CITY OF PORTLAND, MAINE

October 2, 2015

Project Name: Four-Unit Apartment Building
Project ID: 2015-120 CBL: 016 D010 001
Address: 93 St. Lawrence Street
Applicant: Laurence Gross
Planner: Shukria Wiar

From: William Clark
To: David Margolis-Pineo
CC: Shukria Wiar
Date: 9/25/2015 3:26 PM
Subject: 89 Lawrence Street Subdivision and Survey Plans - Survey review 9 25 2015
Attachments: 89 Lawrence St Boundary Topo 6 11 2014 survey review 9 25 2015.PDF; 89 Lawrence St Subdivision Plat rev 9 15 survey review 9 25 2015.pdf

Drawing file: 1. Original Plans / Sheet 1 Boundary & Topographic Survey.pdf

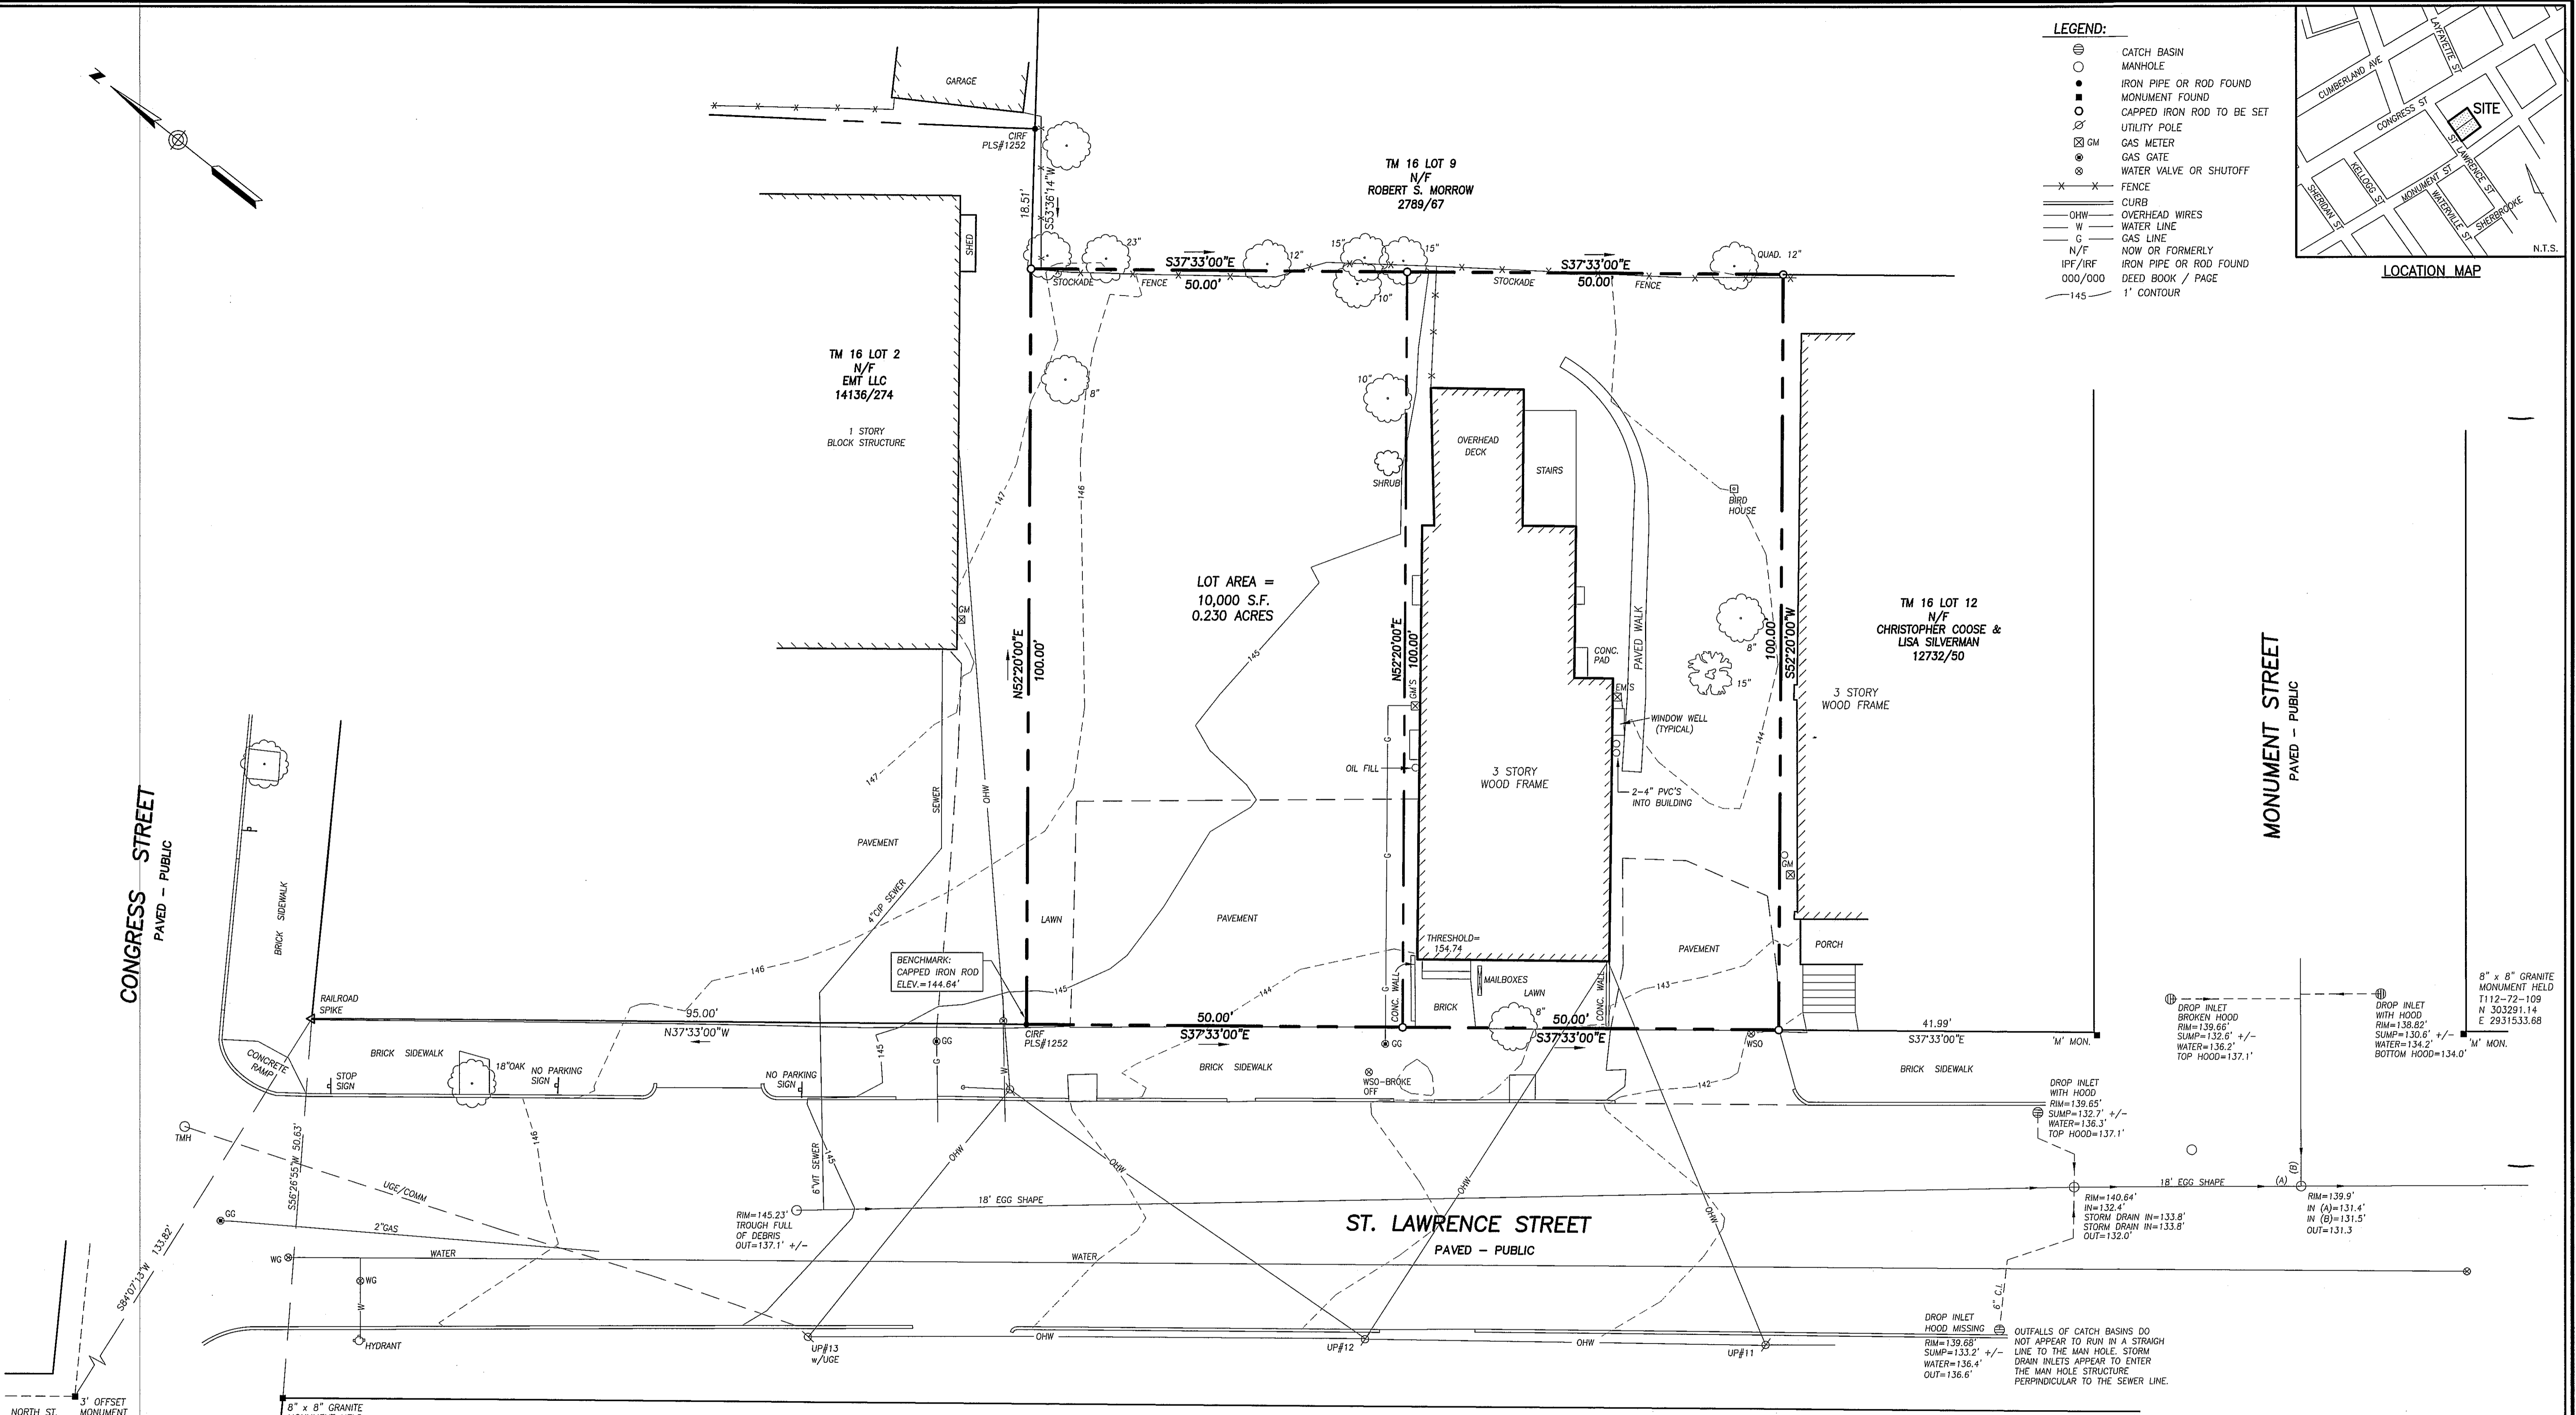
The "Boundary and Topographic Survey" by Owen Haskell, Inc dated 6/11/2014 is very clean and concise. Several items as follows and are shown on the attached plan.

1. Please add State Plane Coordinates for four perimeter corners. This is for updating the City of Portland GIS parcel map.
2. Basis of Bearings. No issue with showing the record magnetic bearing basis. However, the City Working Plans referenced do not have any bearings on them. Bearings match the bearings for the 118 Congress Street project as recorded in Registry Plan Book 214_150, but the 118 Congress Street plan also references the same City Working Plans as a basis of bearing. Could the basis of bearing be plan reference 1, 1926?

3. Benchmark referenced. The monument at Congress Street and North Street is not listed in the Official City Benchmark Card file in the DPS Engineering Archives. Is the source of the 146.69 elevation from a City of Portland Engineering survey field book?

4. The plan shows a gas service line and oil fill along the side of the existing building. I suggest they add a "Proposed Future 5 foot wide gas service/oil fill Easement". Mr Gross cannot grant an easement to himself. However an easement can be created in the future when the existing building or 10,000 SF parcel are sold to separate owners. .

Drawing file: 5. Final Approved Plans and Documents / St. Lawrence St. - 93 #2015-120 (16-D-10) 4 Unit Apt. - Recording Plat.pdf

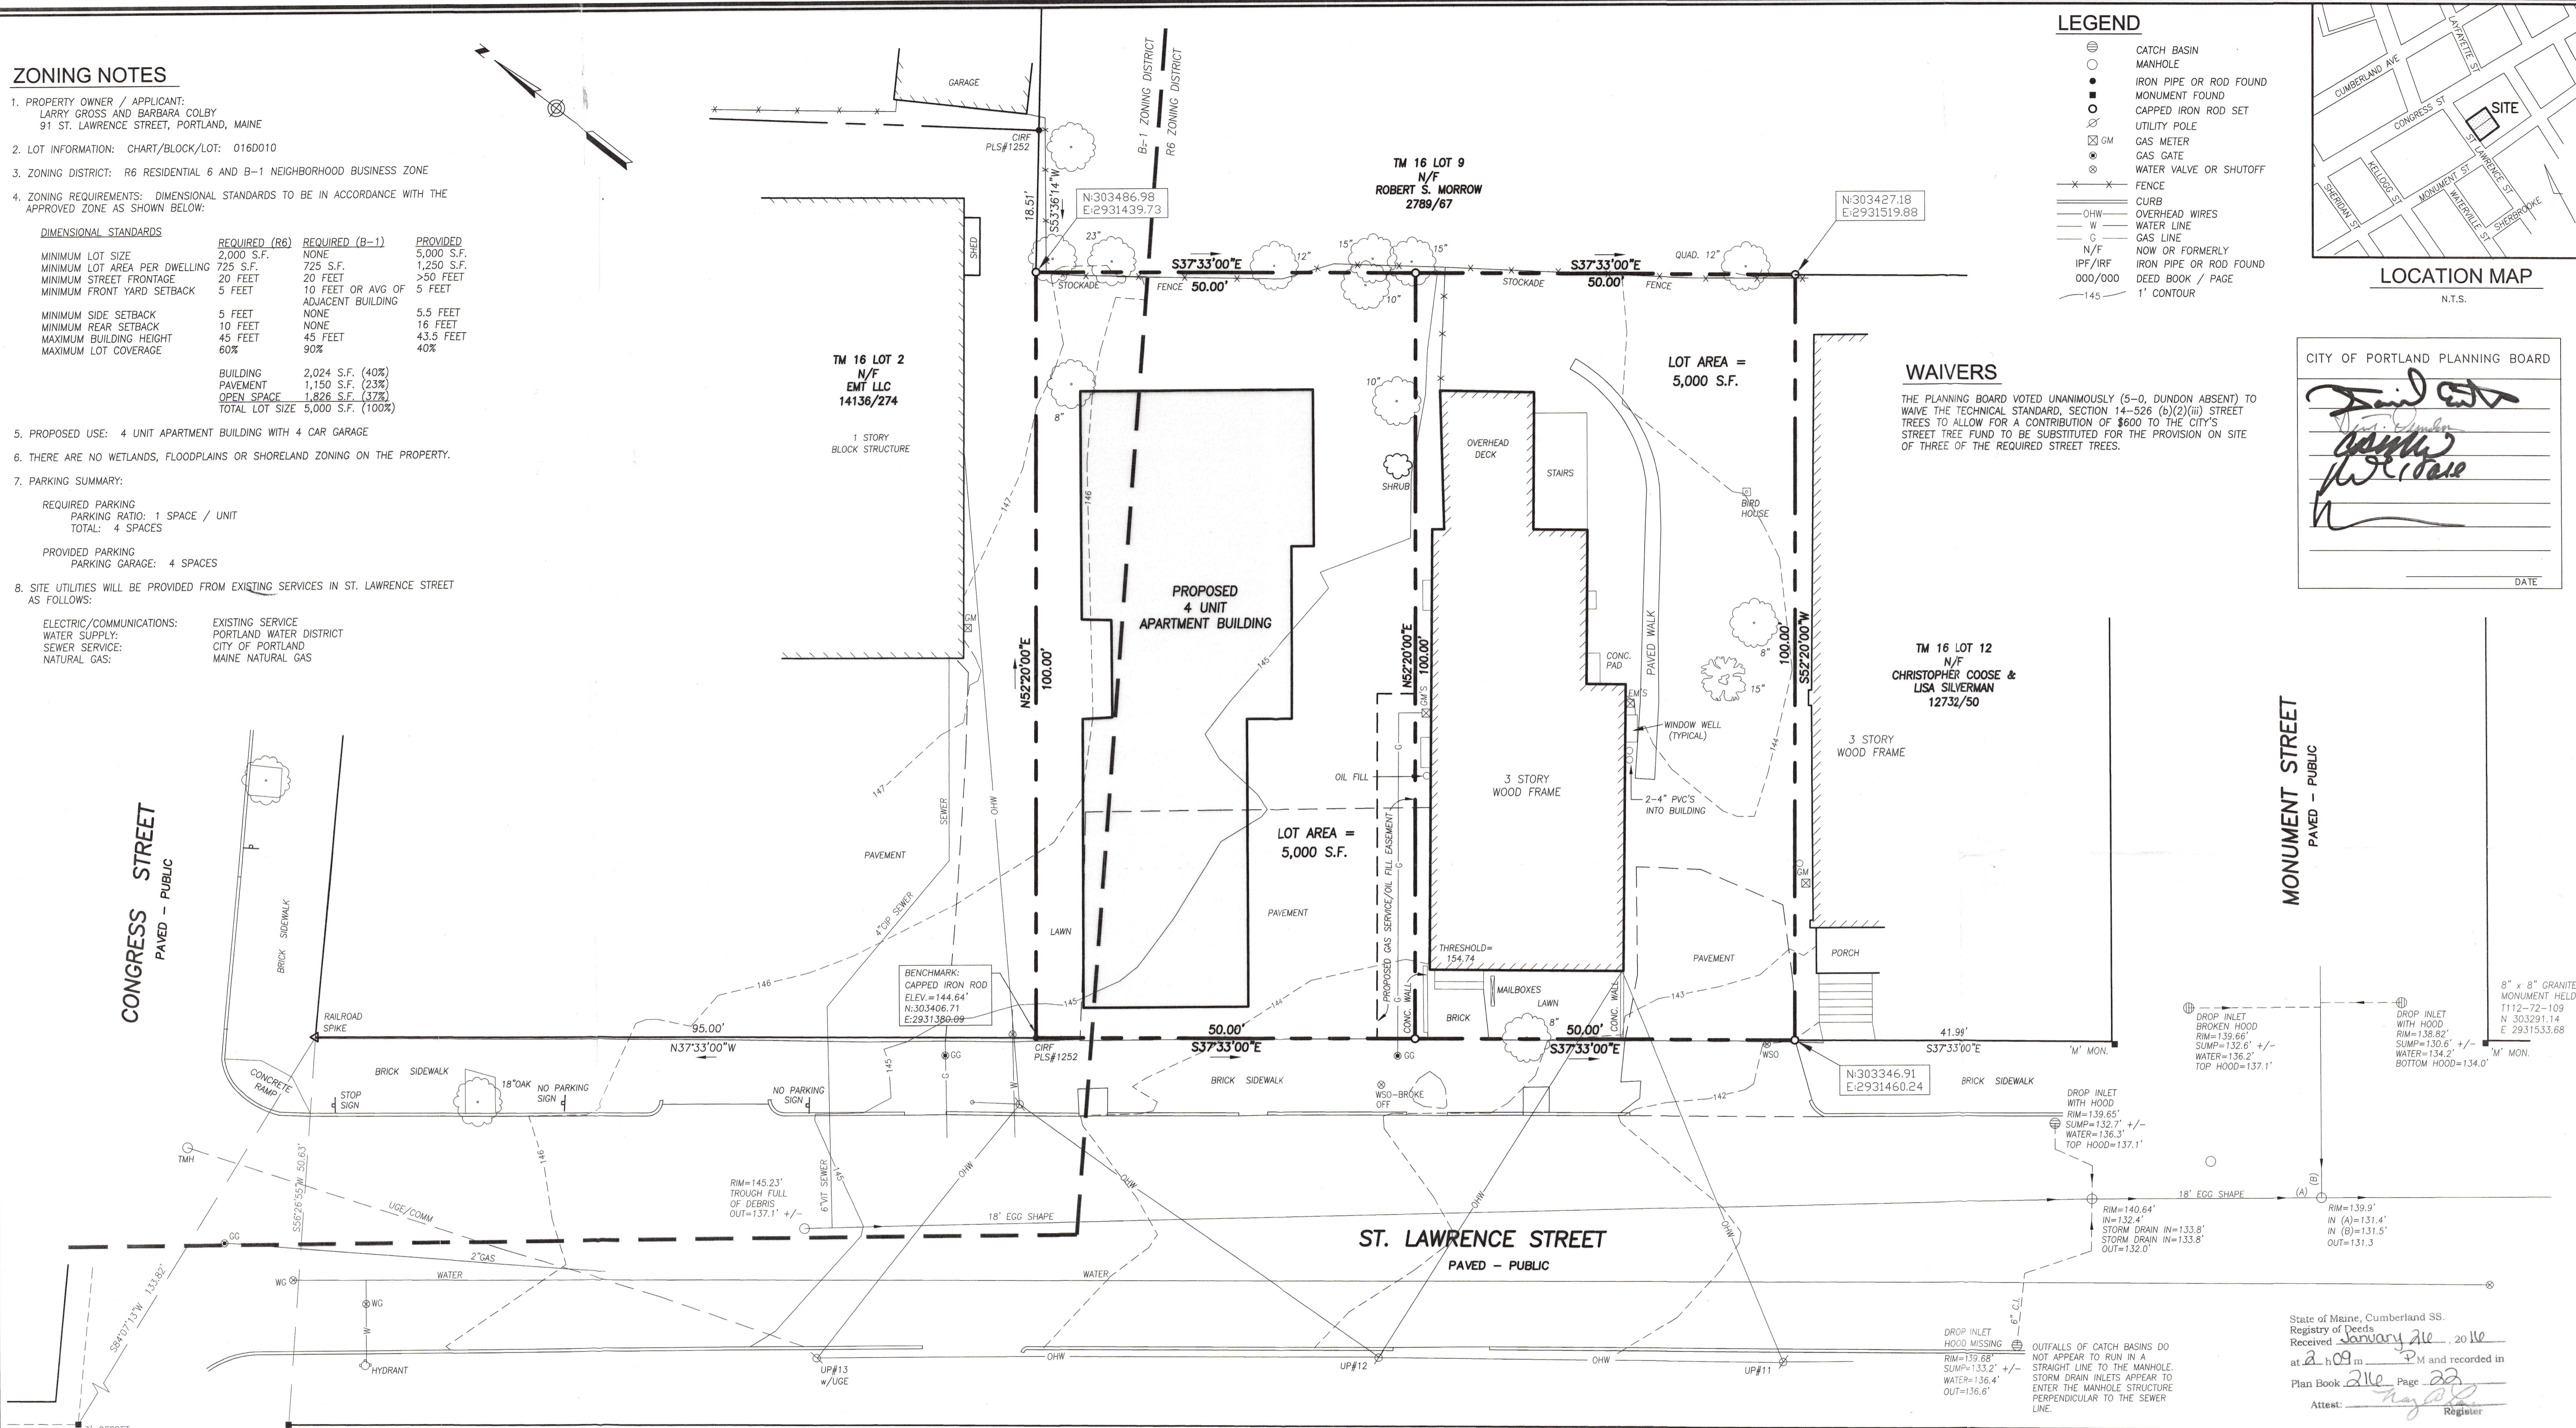
1. The recording plat shall be revised noting all waivers and conditions for review and approval by the Planning Authority prior to recording. All waivers shall be recorded within 90 days of the Planning Board approval; and
2. The applicant shall finalize the subdivision plat for review and approval by Corporation Counsel, the Department of Public Services, and the Planning Authority. The final plat shall address the City's Surveyor's comments dated 09.25.2015.

The "Subdivision Plat" Rev 9/15 needs to be prepared by a Licensed Professional Land Surveyor. Standard elements for a subdivision plan are too numerous to list here. The survey firm Owen Haskell, Inc who prepared the Boundary and Topographic Survey has prepared many subdivision plans in Portland and is extremely qualified to complete the plan.
